Re: Wastewater Capacity Authorization

Address: **23 Ocean Avenue**

Applicant: Stephen & Roberta Cope

UTILITY & STORMWATER MANAGEMENT PLAN

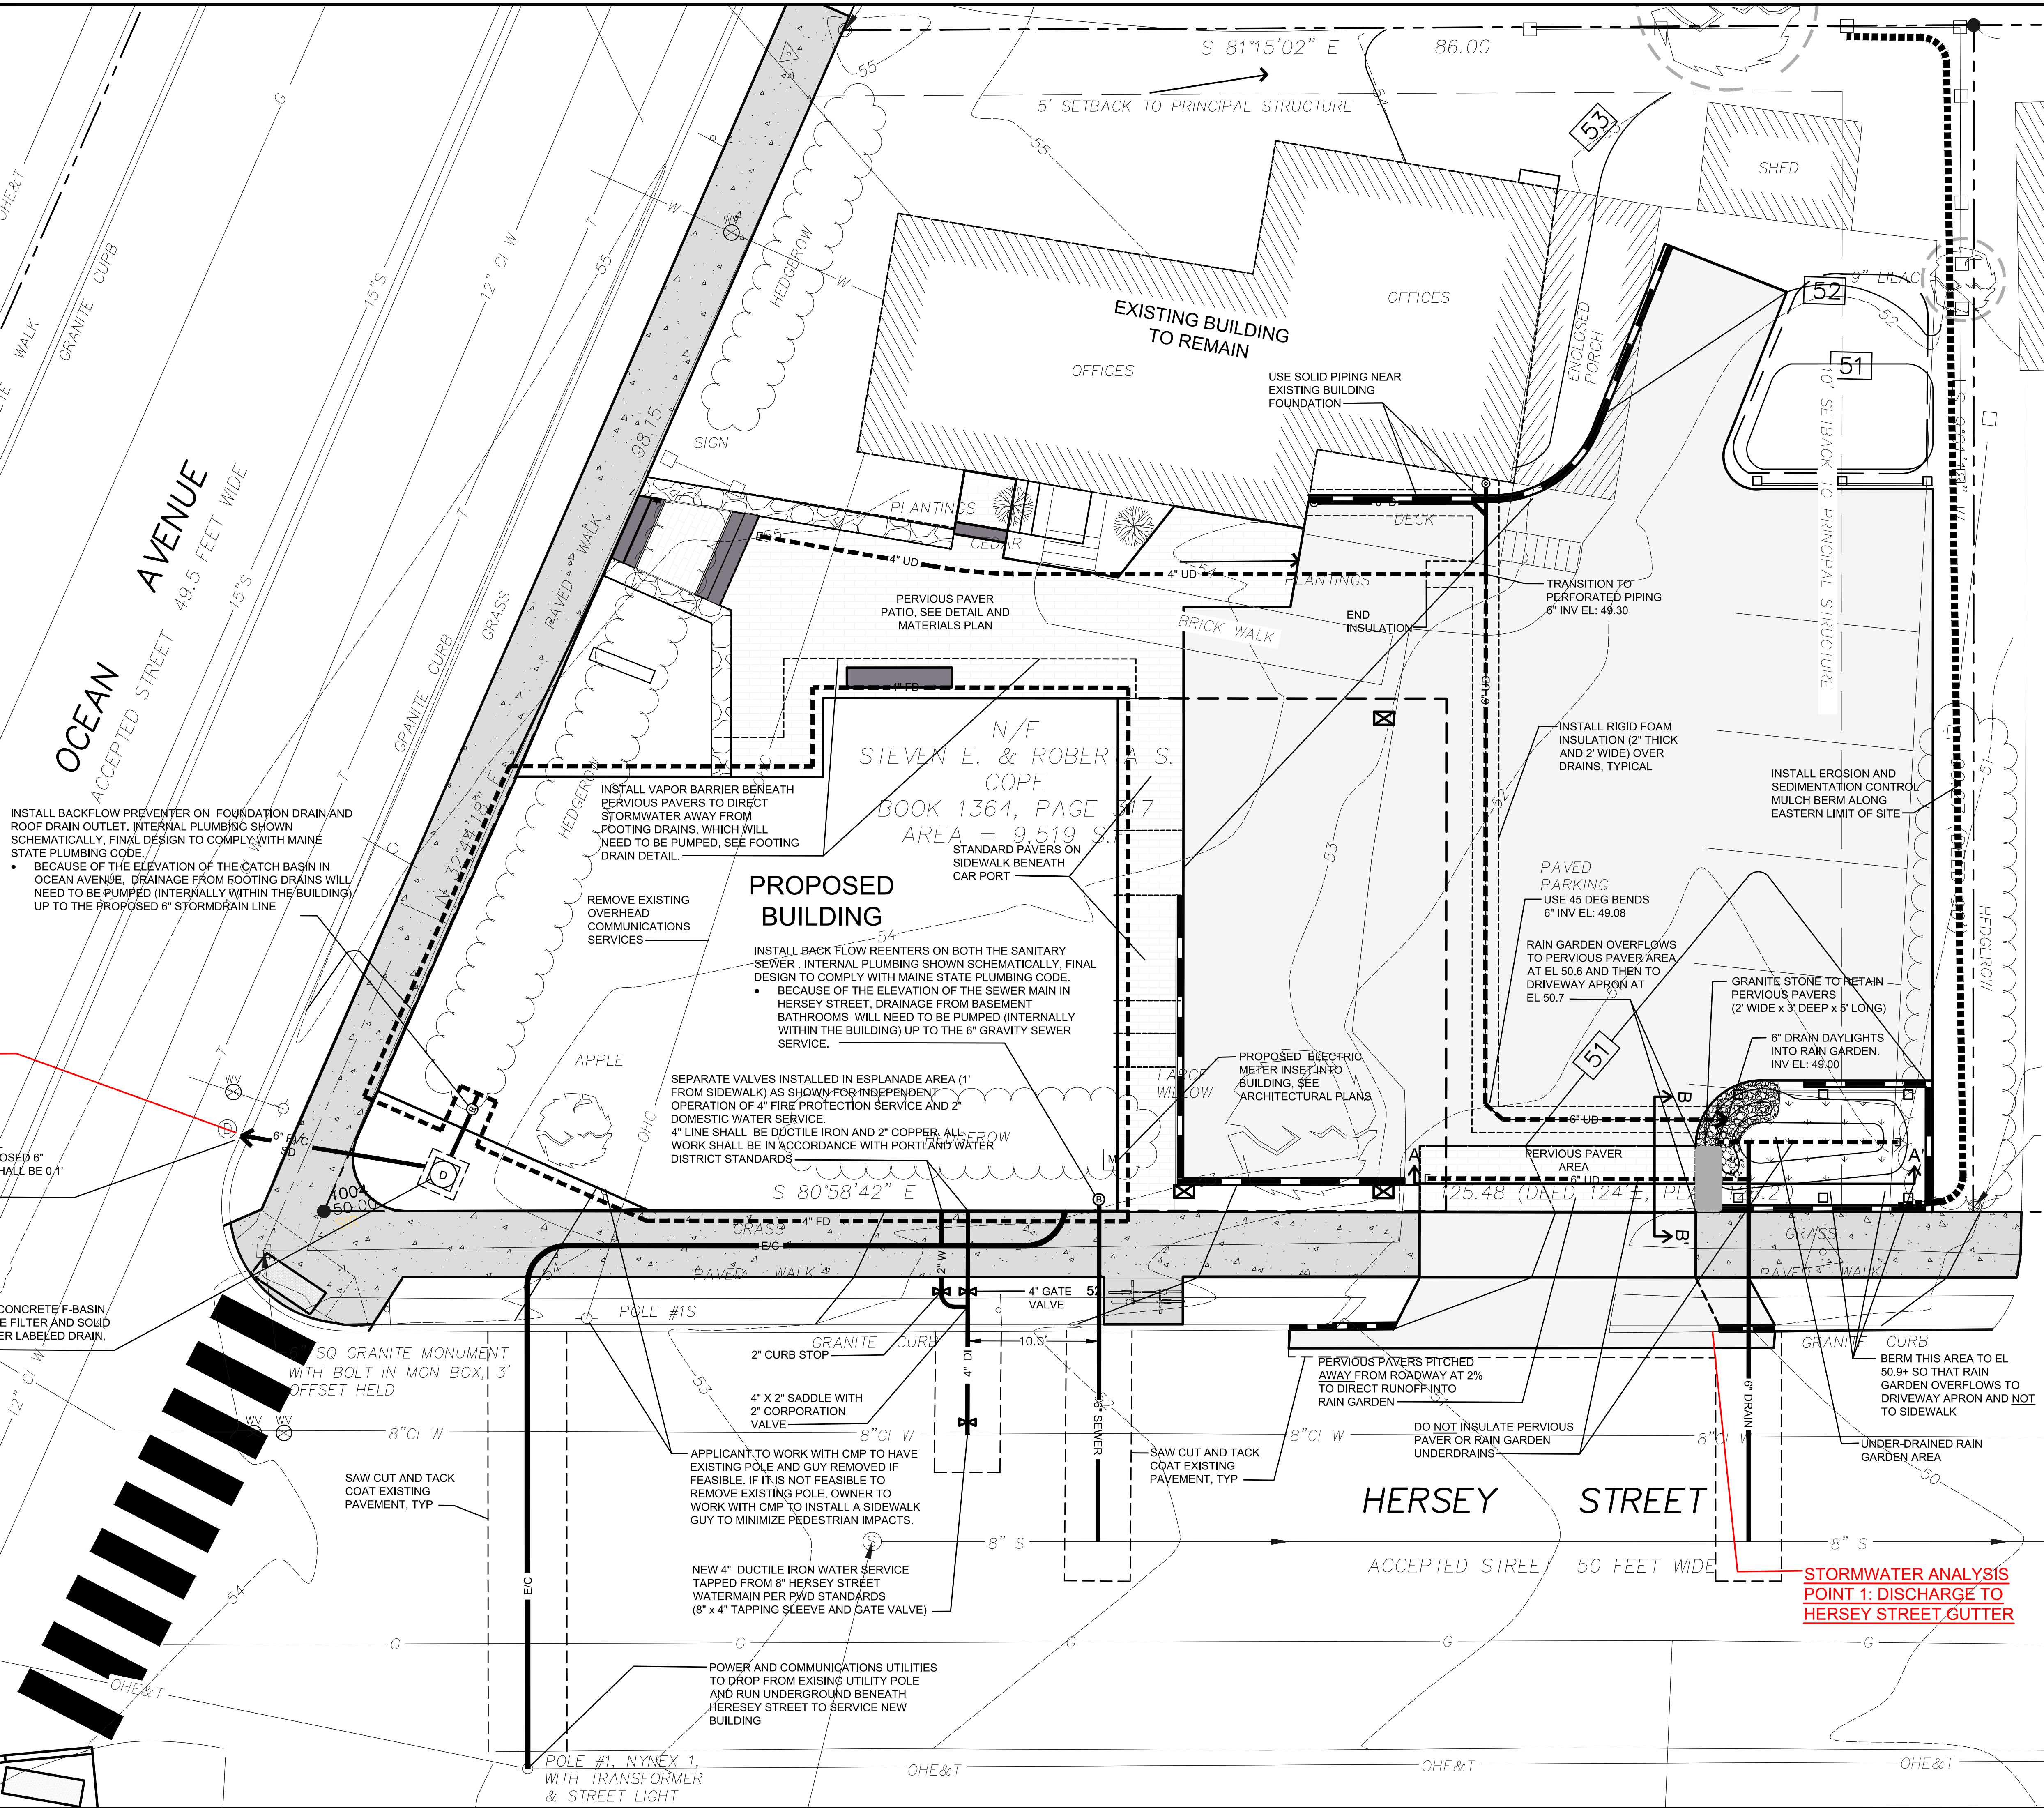
You are reminded that the sewers you are proposing to connect into convey both sanitary and stormwater (Combined Sewer) and therefore a backflow preventer is suggested.

Any addition of stormwater flows in this drainage area will have an impact on discharge volumes at CSO #12 (Vanna Street) into Back Cove. The city is also aware of downstream capacity issues during storm events on the Hersey Street combined sewer, therefore per city ordinance no roof, sump pump or site drainage may be discharged to the combined sewer. It is noted on your Utility & Stormwater Management Plan C-1 the intent to connect the rain garden underdrain into the sewer system. As the location presents no opportunities to connect to a separate storm drain system, the city will allow the connection into the combined sewer and appreciates the effort to incorporate green infrastructure which should see some mitigation to the storm flows entering that system. Further site plan review and comments I believe have been provide separately.
